## Application for a non-material amendment following a grant of planning permission.

Number	80
Suffix	
Property name	
Address line 1	Monks Avenue
Address line 2	
Address line 3	
Town/city	Whitley Bay
Postcode	NE25 9RT
Description of site location must be completed if postcode is not known:	
Easting (x)	433519
Northing (y)	571391
Description

<input type="text" value="Single storey side extension"/>	
Reference number:	<input type="text" value="20/00487/FULH"/>
Date of decision	<input type="text" value="10/06/2020"/>

removing the separation in the single storey extension

Drawing No. PL-001

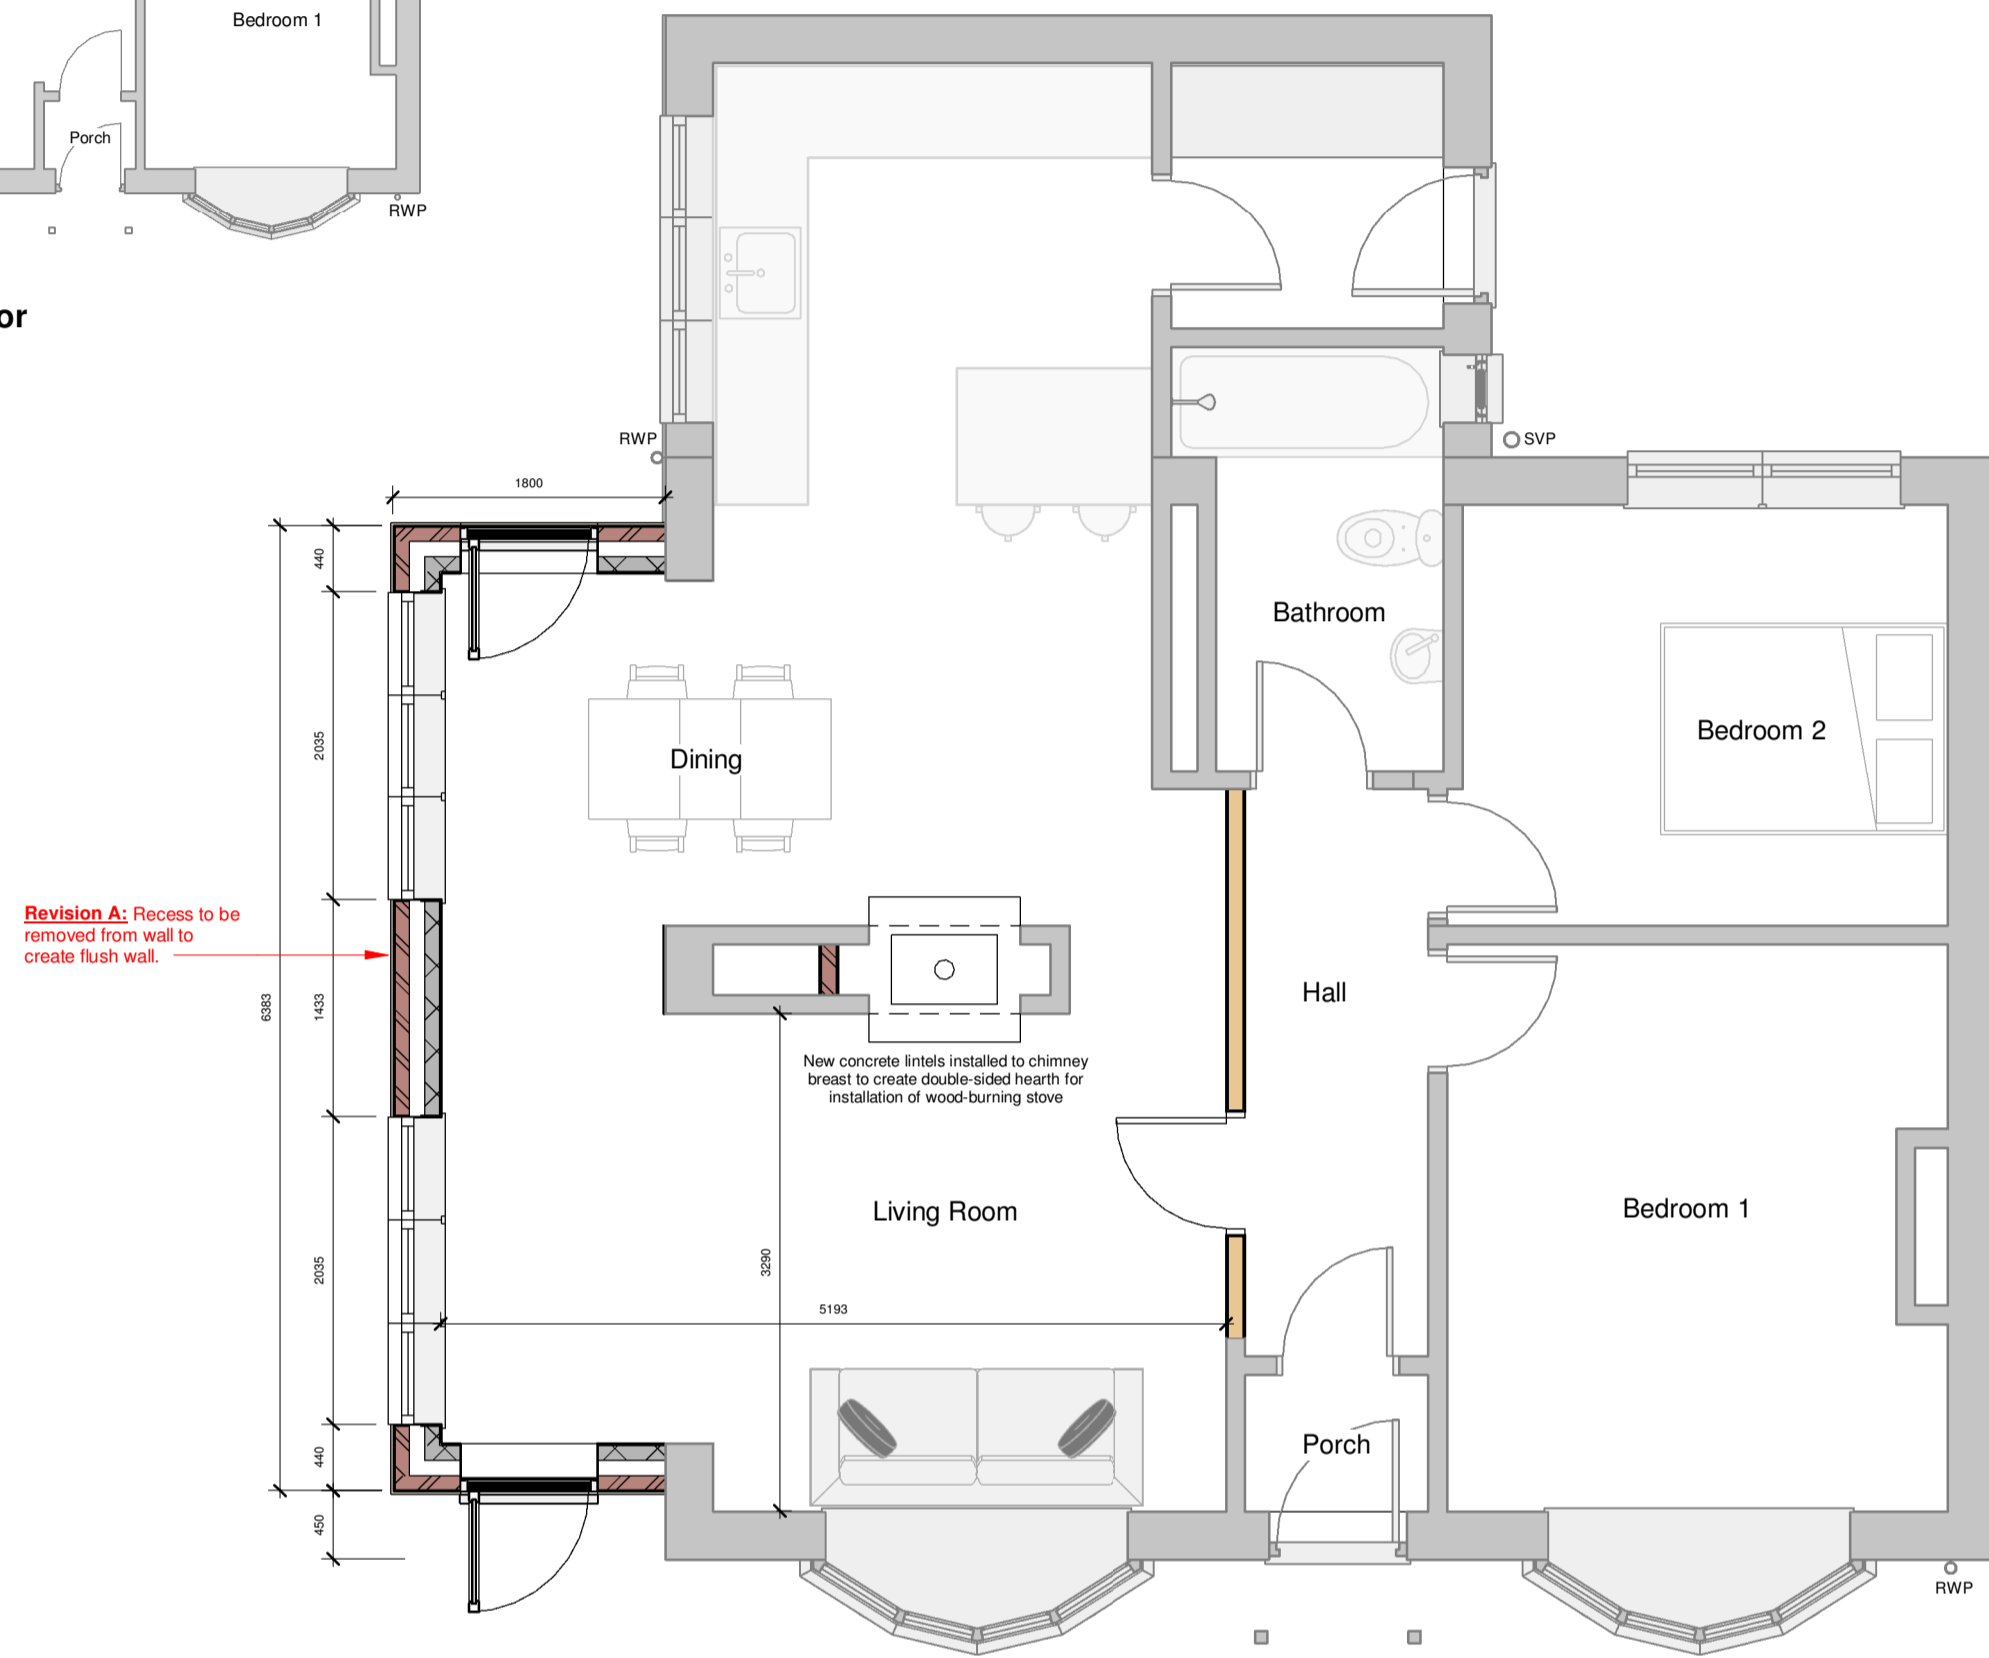
Client would like to have the additional space to be open
